CITY OF ALBUQUERQUE
MUNICIPAL DEVELOPMENT DEPARTMENT
ENGINEERING DIVISION

SUBJECT: PANORAMA SELF STORAGE
TRACT T-2, PANORAMA HTS. ADDN.

REF: PANORAMA SELF STORAGE UNITS TRACT T-2 (J22-D40)

Based on the information provided on your October 17, 1984 submittal of the above referenced drainage plan, listed you will find certain items that will need to be addressed before final approval is granted:

GRADING & DRAINAGE PLAN
PANORAMA SELF STORAGE UNITS

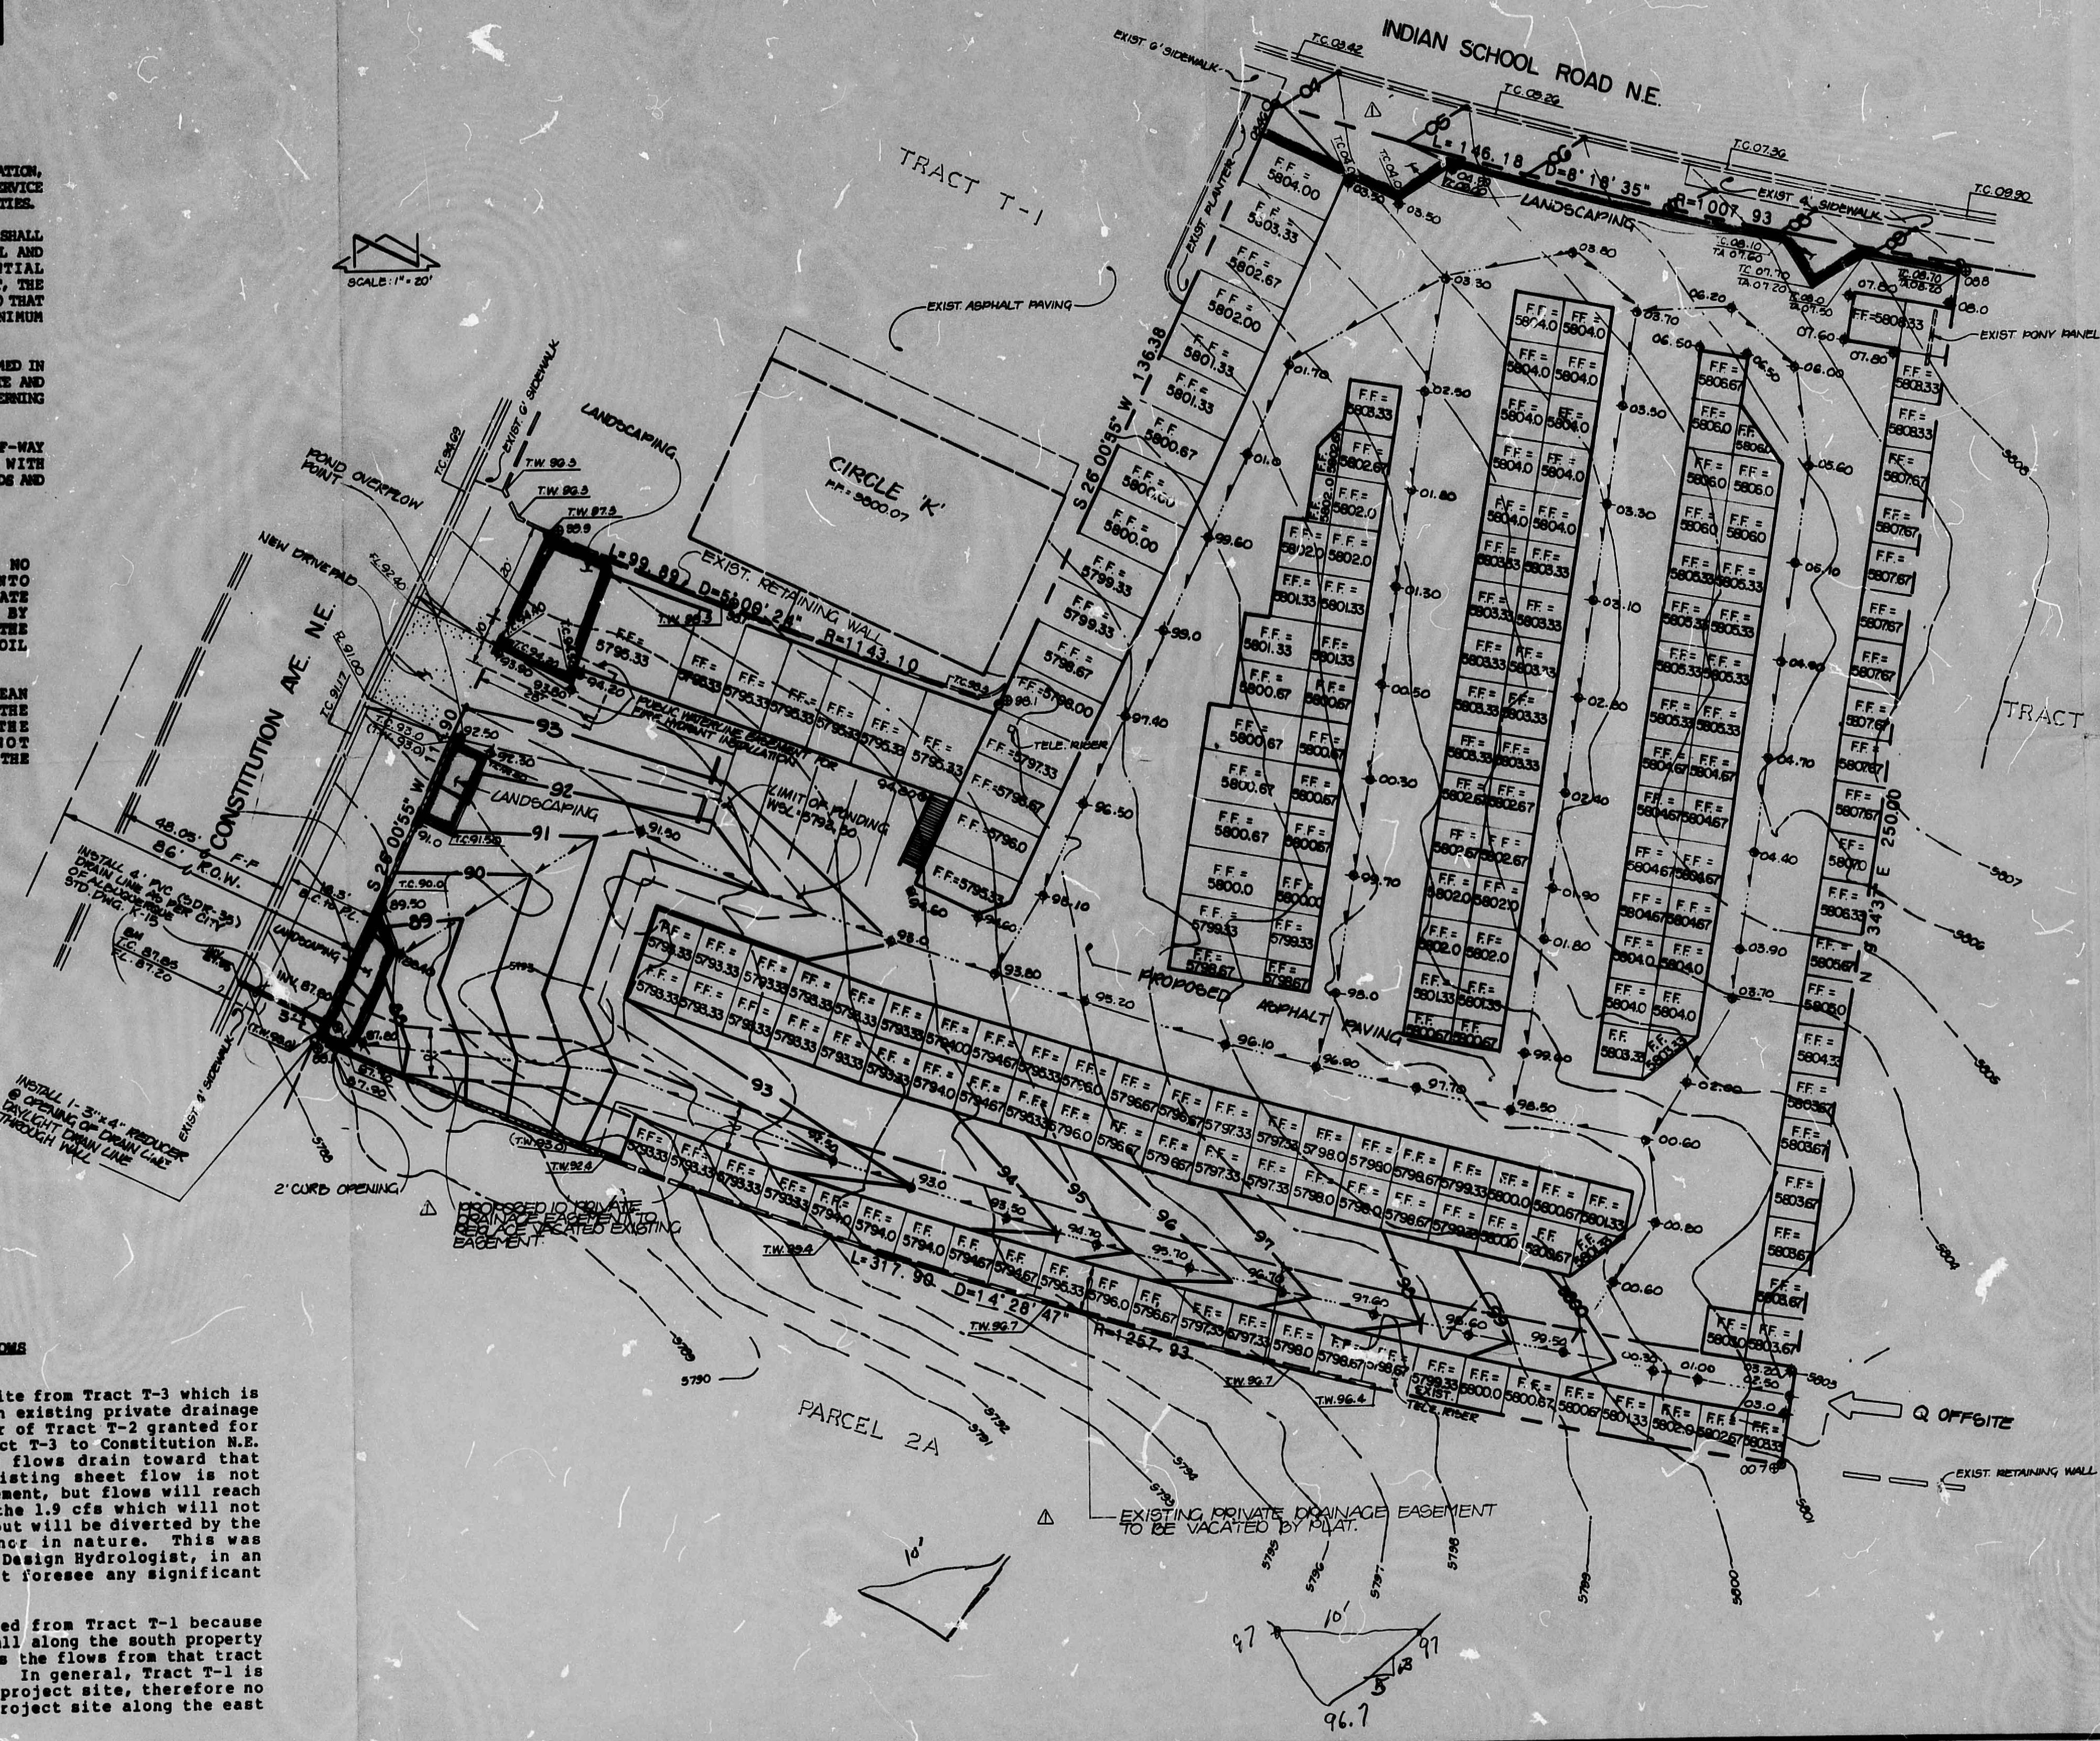
- 1 - DRAINAGE plan REQUIRED per DPM PRIOR TO BUILDING PERMIT SIGN-OFF.
- 2 - Identify PURPOSE OF 10' DRAINAGE EASEMENT
- 3 - CONTROLLED DISCHARGE REQUIRED BECAUSE OF FLOODING DOWNSTREAM

- ✓ 1. Information sheet with resubmittal designation.
- ✓ 2. Professional engineer's stamp with revised date.
- ✓ 3. Please be advised that site development plan sign-off is required.
- ✓ 4. I will need a copy of signed off replat showing the realignment of the existing easment.
- ✓ 5. Location and direction of roof drains.
- ✓ 6. Elevation of property line adjacent to Indian School Road in some areas is not to the required .33' above top of curb.
- ✓ 7. Details of pond, swales and any significant structures will need to be included.
- ✓ 8. Your plan shows that there is an existing ^{Sheet} street flow pattern from northeast to southwest. The proposed storage units will be blocking the flows, please address.
- ✓ 9. Off-site flows from Tract T-1 must also be addressed.

Comment 4: A replat is being prepared to reconfigure the private drainage easement which serves Tract T - 3. Because this replat involves a vacation, it requires a 30 day advertisement. Because of this delay, it is requested that the drainage plan be approved with the condition of plat approval being a requirement for obtaining a C.O.

Comment 5: Roof drainage has been addressed by Note 2 appearing on the sheet.

Comment 6: The area between Indian School Road N.E. and the north property line has been graded to attain a minimum rise in grade of 0.33 feet from top-of-curb to property line.

Comment 7: The pond water surface level has been identified, the limits of the proposed retaining wall have been shown along with existing and proposed wall elevations, the curb opening has been specified to permit runoff to leave the paving and enter the landscaping before discharging from the site, the pond outlet has been specified and a "Drainage Facilities Within Public Right-Of-Way" has been

prepared and approved. This is ample detail to construct this small detention facility. The owner/builder concurs.

Comments 8 and 9: Additional text has been added to address offsite flows.
